**PLANNING ACT 2008
APPLICATION BY HIGHWAYS ENGLAND FOR AN ORDER GRANTING
DEVELOPMENT CONSENT FOR THE A303 SPARKFORD TO ILCHESTER
DUALLING
SUBMISSION MADE PURSUANT TO DEADLINE 7**

PLANNING INSPECTORATE REFERENCE TR010036

**PLANNING ACT 2008
APPLICATION BY HIGHWAYS ENGLAND FOR AN ORDER GRANTING
DEVELOPMENT CONSENT FOR THE A303 SPARKFORD TO ILCHESTER
DUALLING**

SUBMISSION MADE PURSUANT TO DEADLINE 7

Appendix 1 APPROPRIATE MITIGATION FOR STOPPING UP OF TERMINUS OF BRIDLEWAY Y 30/28 (EASTMEAD LANE)

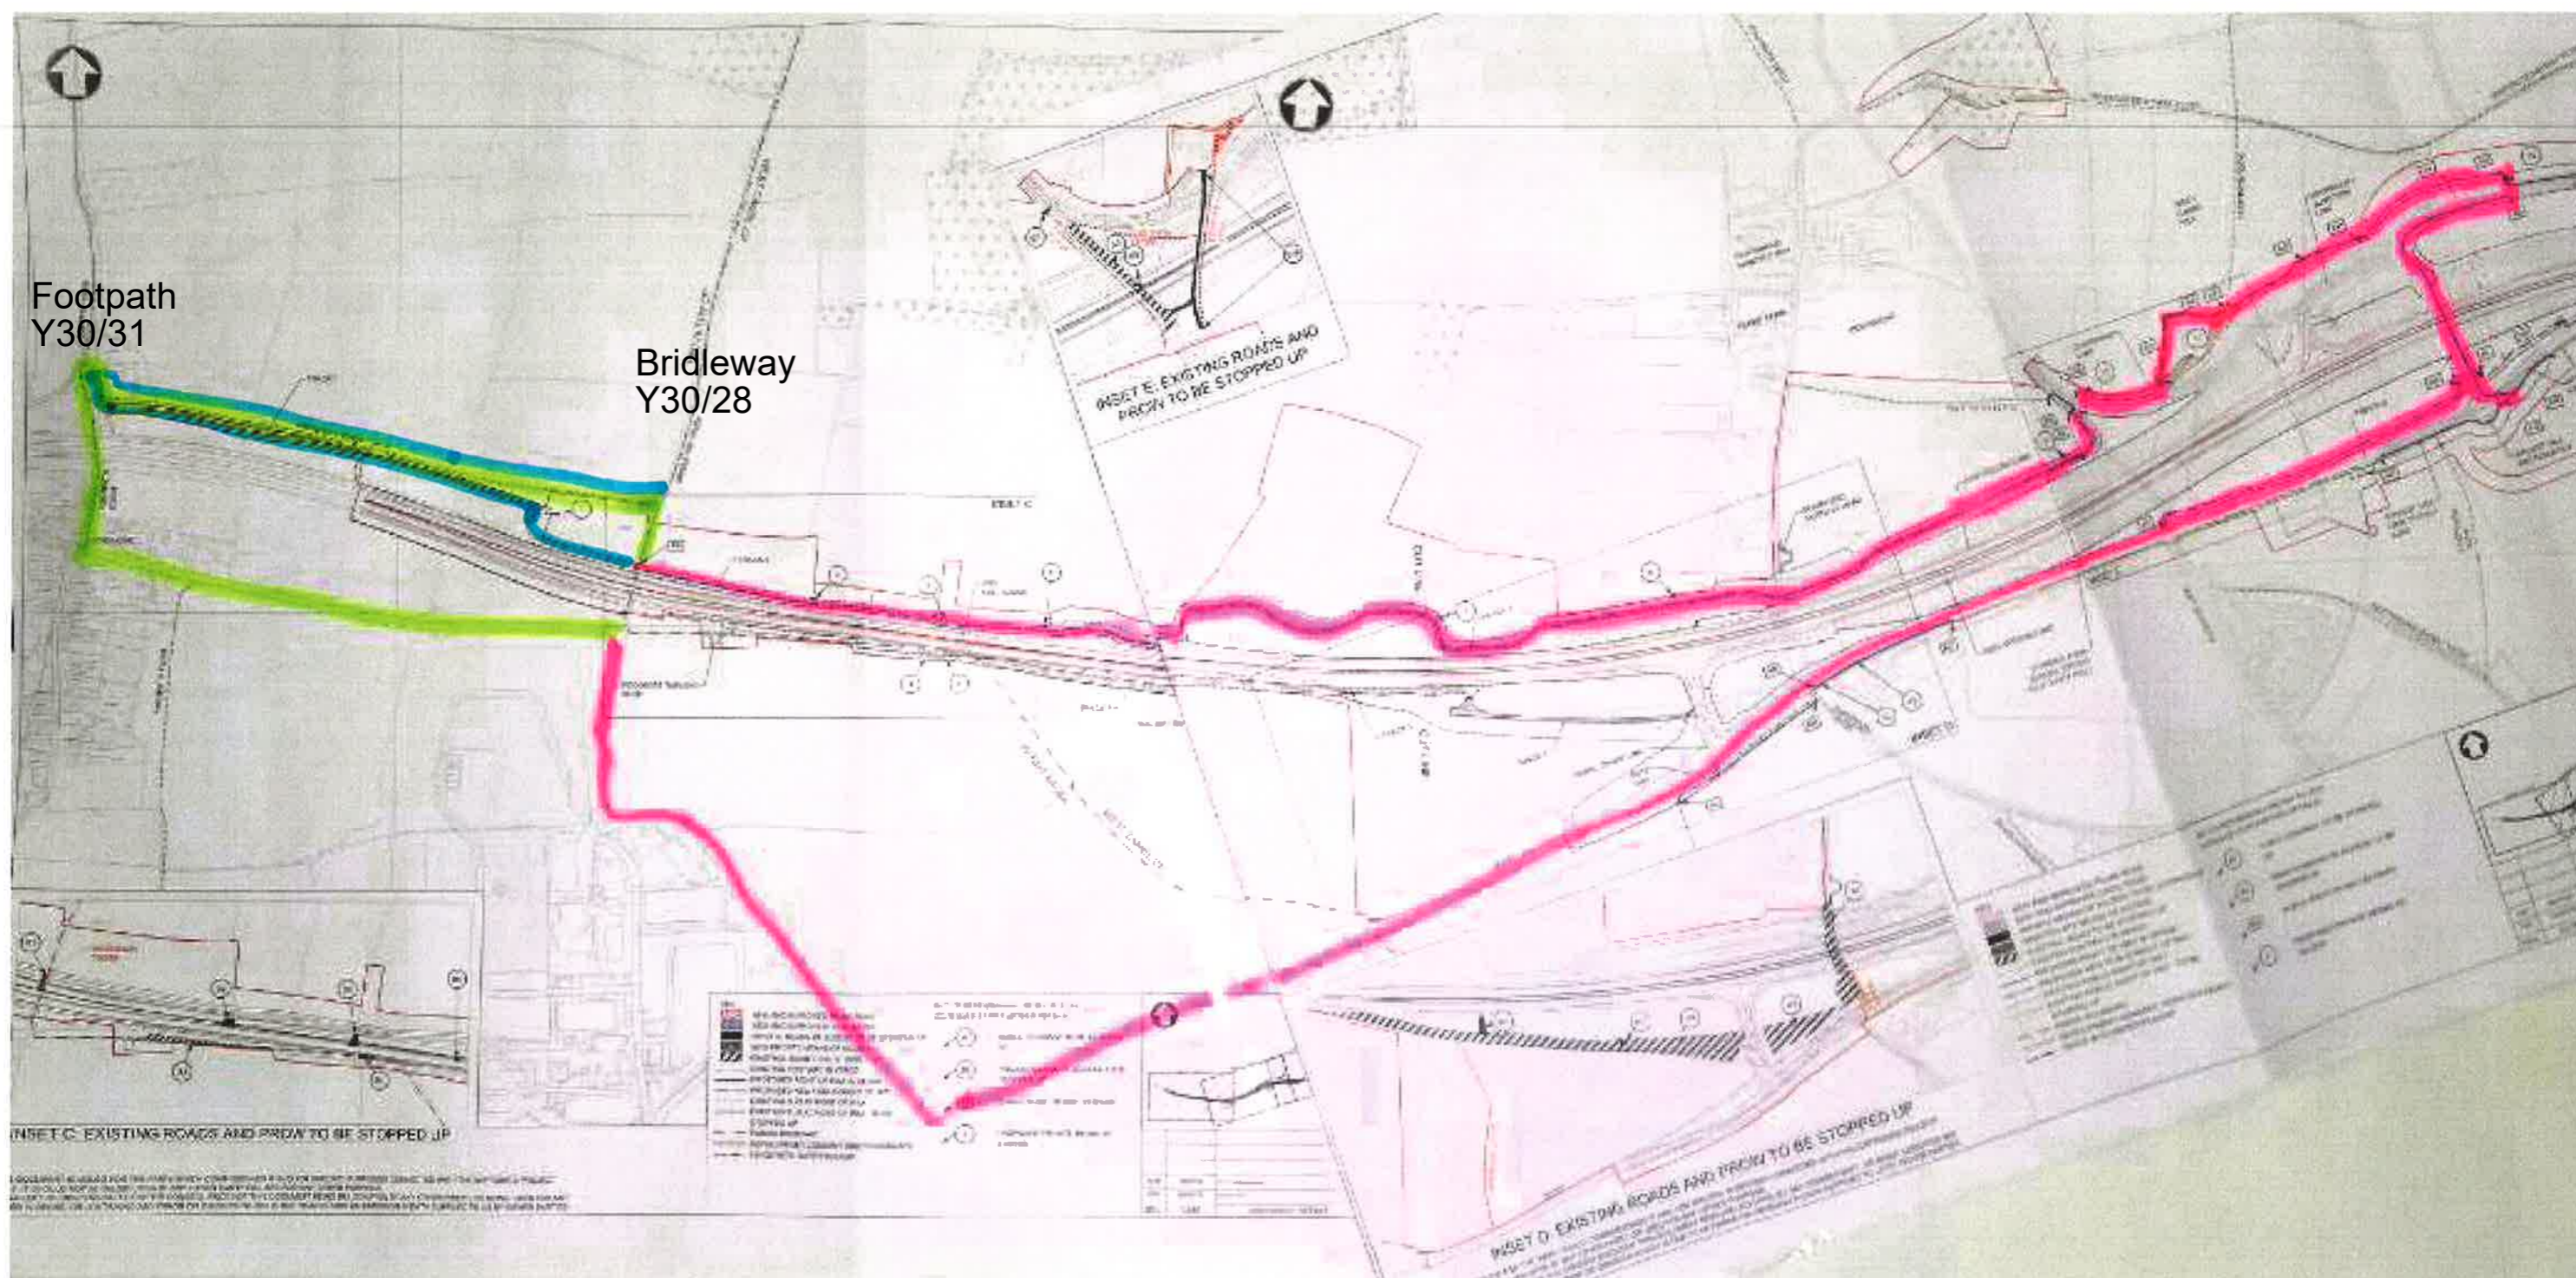
ISH5 Action 5 - Formally submit documents submitted to ExA in relation to revocation of 1996 SRO and mitigation of route loss for Y 30/28.

See Appendices 1 & 2. Please note that the 0.8km previously tabled at ISH5 in Appendix 1 was incorrect and now reads as 1.6km. Please note that the digital route of bridleway Y 30/29, as has been shown on the County Council's Explore Somerset mapping and thus the DCO Rights of Way & Access Plans, is not an accurate representation of the route shown in the 1996 Side Road Order. Please see Appendices 4 & 5 for plans/ extracts showing the route that was intended by the Order.

The County Council’s position has always been that a bridleway connection between Podimore and Y 30/28 (Eastmead Lane) via Y 30/31 (Higher Farm Lane) is appropriate mitigation for the stopping up of the southern terminus of Y 30/28 (see separate topic paper submitted at deadline 2), and therefore should form part of the DCO. In the absence of any appropriate mitigation the County Council previously sought a requirement to secure an obligation. This has not been forthcoming hence the Council now requires a legal agreement with the applicant under s278 Highways Act 1980. Noting the County Council’s response to ISH5 Action 6 and the existence of bridleway Y 30/29, the heads of terms for this aspect of a s278 agreement would be as follows:

- The applicant to undertake works on their Higher Farm Lane overbridge to accommodate horse riders, through the upgrading of parapets or the provision of mounting blocks and associated signage.
- The applicant to dedicate bridleway rights, with a clause to dedicate restricted byway rights should such rights be confirmed over Y 30/28 Eastmead Lane), over land that they own as far as it is necessary to secure.
- To provide a contribution of £70k to enable the Council to secure, process and defend any necessary agreements and orders, and to secure the necessary rights and works over land that is outside of the ownership of the applicant. Any remaining balance could be refundable.

Appendix 2 POTENTIAL LEGACY ISSUES IF ONLY PARTIAL REVOCATION OF 1996 SRO

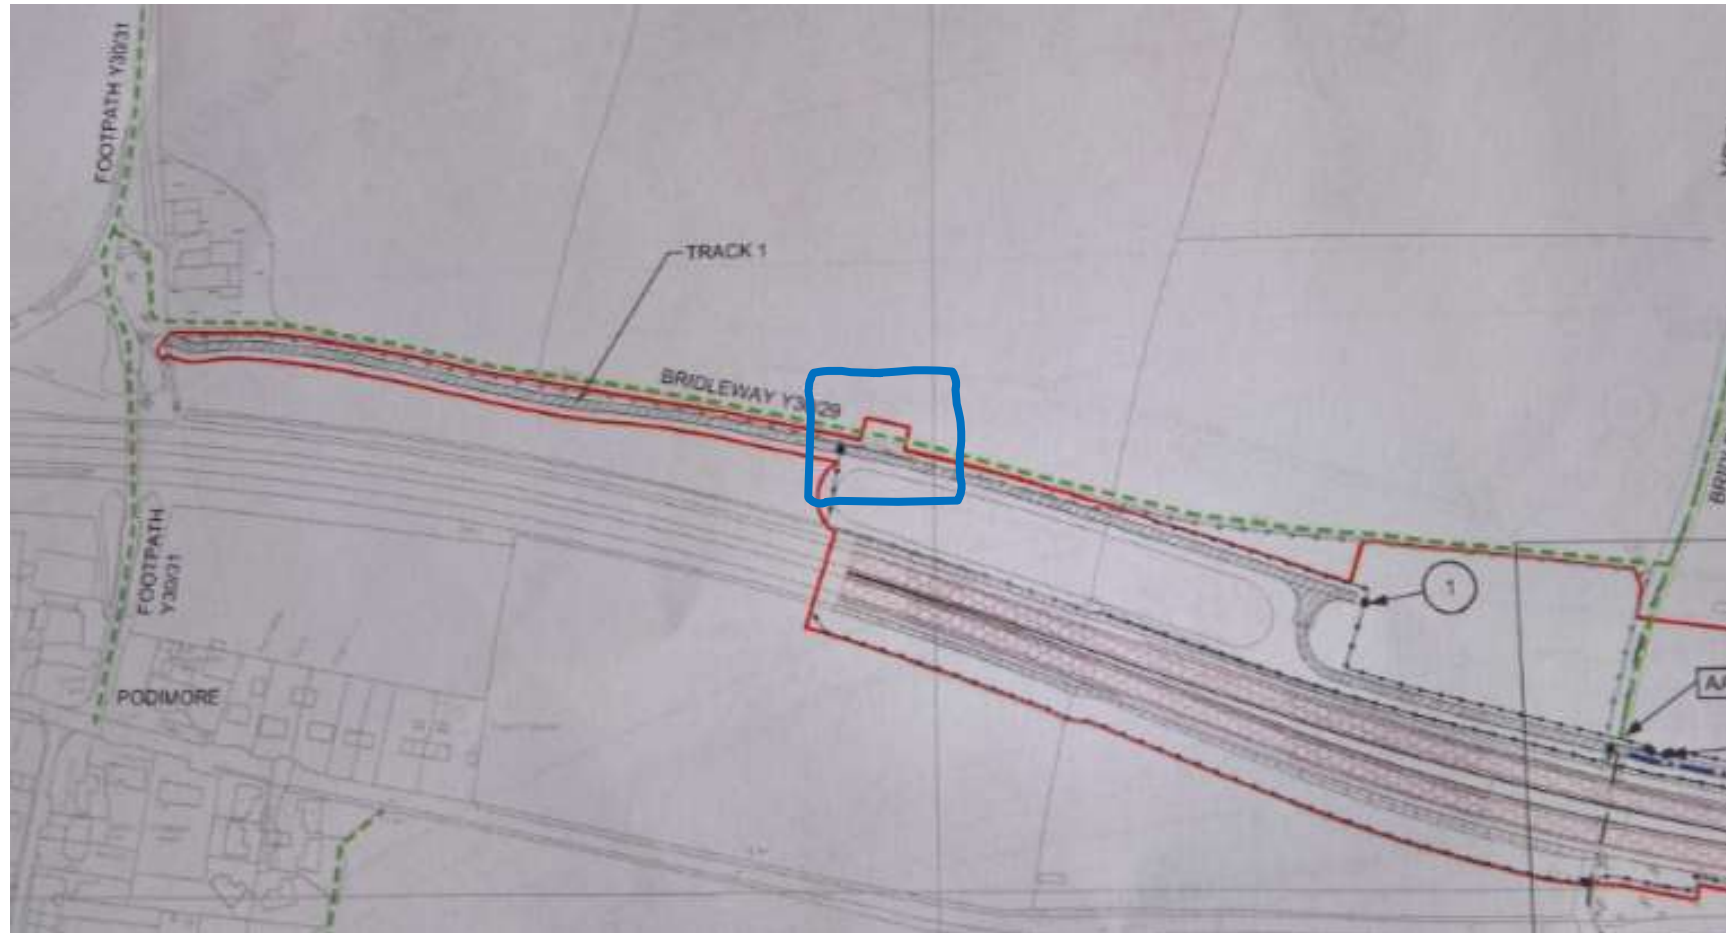
It appears that the County Council only recognised two new routes in updating its digital mapping (bridleway Y30/29 and footpath Y 27/UN), and none of the effects of the 1996 SRO were updated on the legal record, the Definitive Map & Statement (DMS). Strictly speaking, a legal event modification order should be processed to update the DMS in recognition of the legal event that occurred in 1996. This is far from a practical solution given the scheme did not progress, hence the Council's previous position has been that the SRO should be revoked in full either as part of or in parallel to the DCO.

In the apparent absence of the applicant undertaking comparison analysis of the 1996 SRO and the DCO Rights of Way & Access Plans, the County Council has prepared a document in draft form which can be found at Appendix 4. The tight deadlines have not allowed for a computer-generated overlay of the various legacy issues but the extracts of the two Orders should assist the Examining Authority in understanding the complications that would arise should the applicant pursue a partial revocation of the 1996 SRO within the order limits only. The analysis identified 3 other routes that are technically created and associated routes extinguished in the vicinity of Camel Hill.

The current drafting promoting partial revocation within the order limits would result in a number of cul-de-sacs and isolated sections of right of way. Whilst the applicant gave reassurance at ISH5 that the issue in relation to Y 30/29 could be addressed through DCO redrafting, the additional legacy issues that have been identified call into question the best way to approach this issue. It would not be an acceptable outcome to the County Council to update the DMS with the effect of the 1996 SRO and then further update with the effects of the partial revocation within the DCO limits. It would

create a nonsensical rights of way network in places, which the County Council should not be burdened with to resolve.

The County Council's position is thus; that the 1996 SRO should be revoked in full, save for:

- Schedule 1 – new highway A (bridleway)
- Schedule 2 – new highway G (bridleway)

## Routes affected by partial revocation of A303 Trunk Road (Sparkford to Ilchester Improvement and Slip Roads) (Side Roads) Order 1996

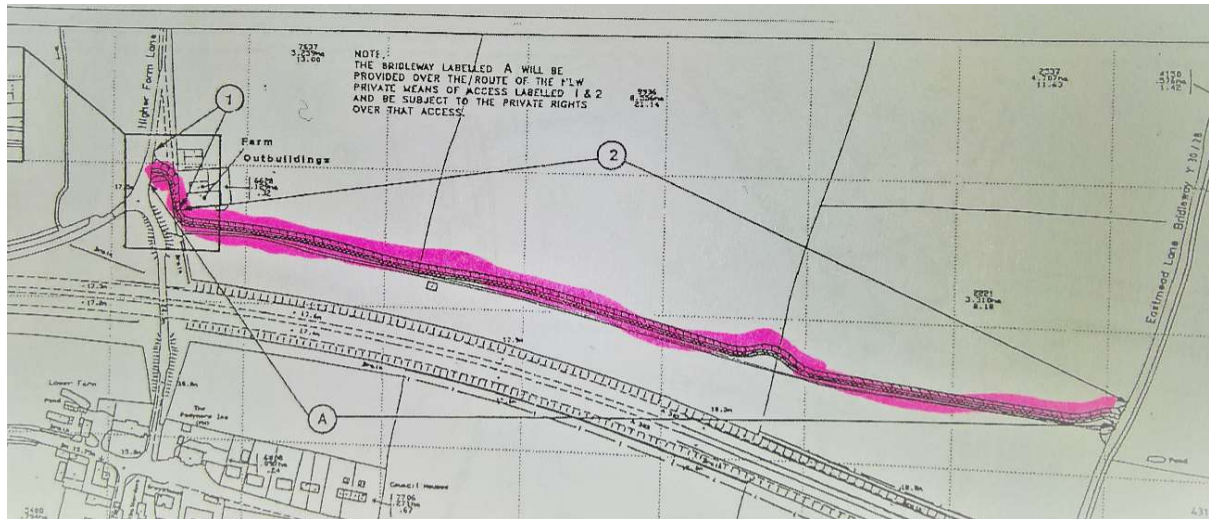
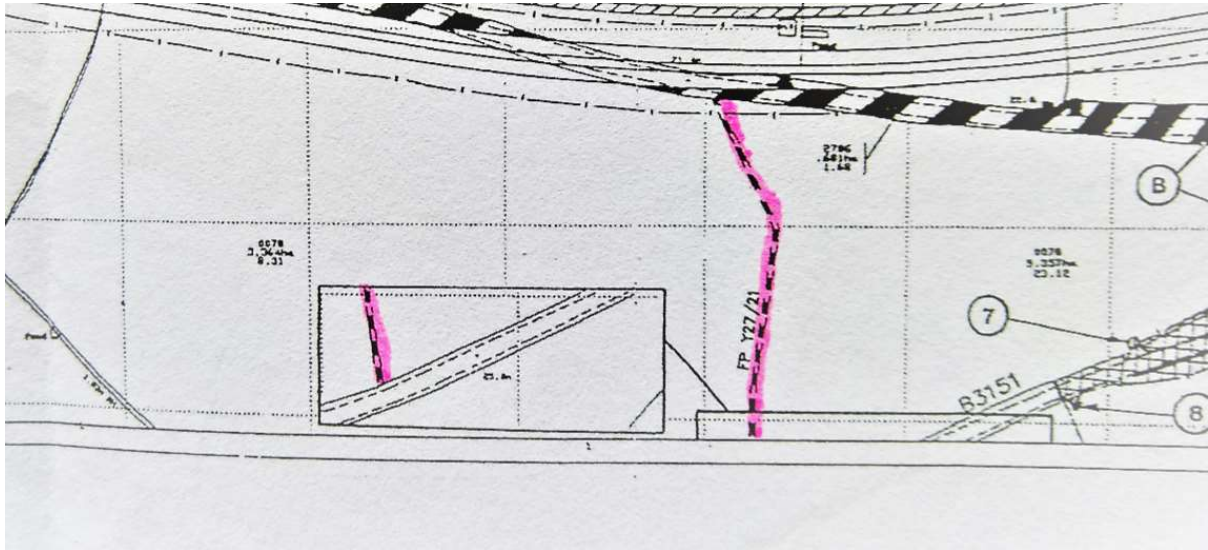
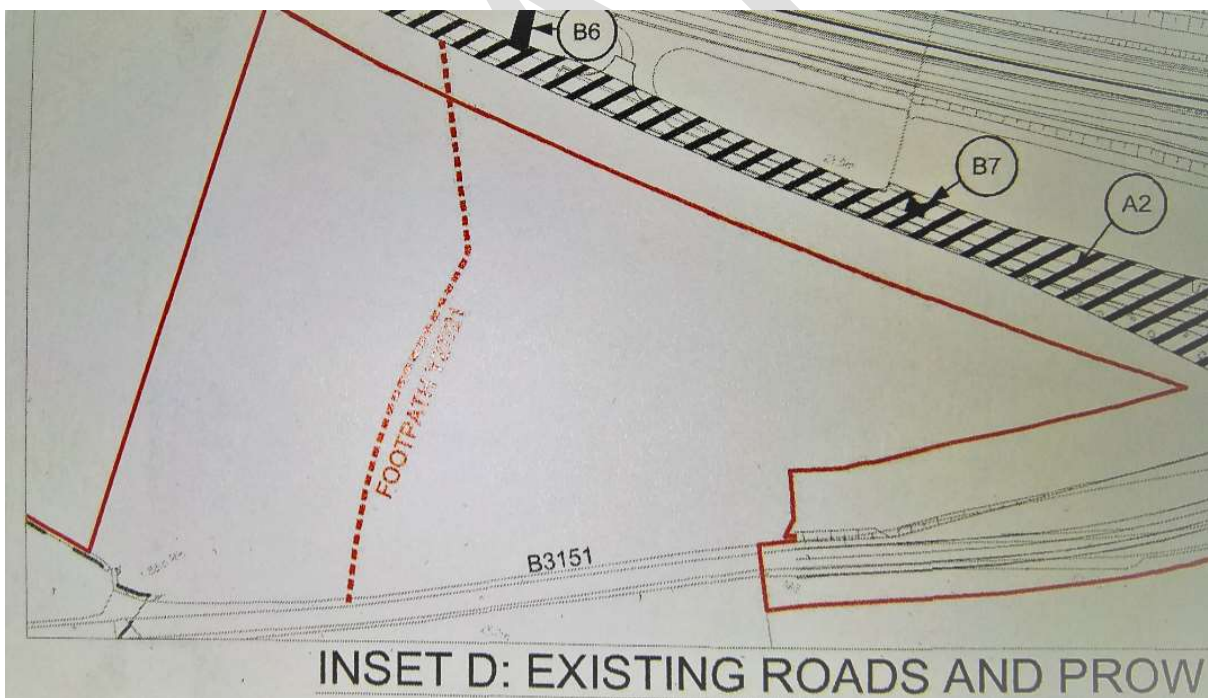
- The discovery of additional 1996 SRO legacy issues in addition to that of bridleway Y 30/29
- The continued resistance of the applicant to provide appropriate mitigation for the stopping up of Y 30/28 within the DCO
- The non-material amendment that has been submitted in relation to the route between Traits Lane and Gason Lane
- Further legal advice that has been obtained,

In light of the routes not being wholly within the red line and the possibility that this cannot be resolved at this point in the process, the County Council would seek the following:

- A s278 Highways Act agreement with the applicant that would cover the establishment costs for both routes. For route 'A' (Y 30/29) this would be in the order of £5k and for route 'G' this would be £20k. Any remaining balance could be refundable. Such costs may be capable of being offset if the applicant carried out appropriate establishment works within the red line boundary.
- Further to securing the above agreement, the Examining Authority to recommend in light of the DCO process and any revised drafting in relation to revocation of the 1996 SRO, that the Secretary of State formally notifies the County Council that they become responsible for the new highways as referenced above (Schedule 1 'A' and Schedule 2 'G')
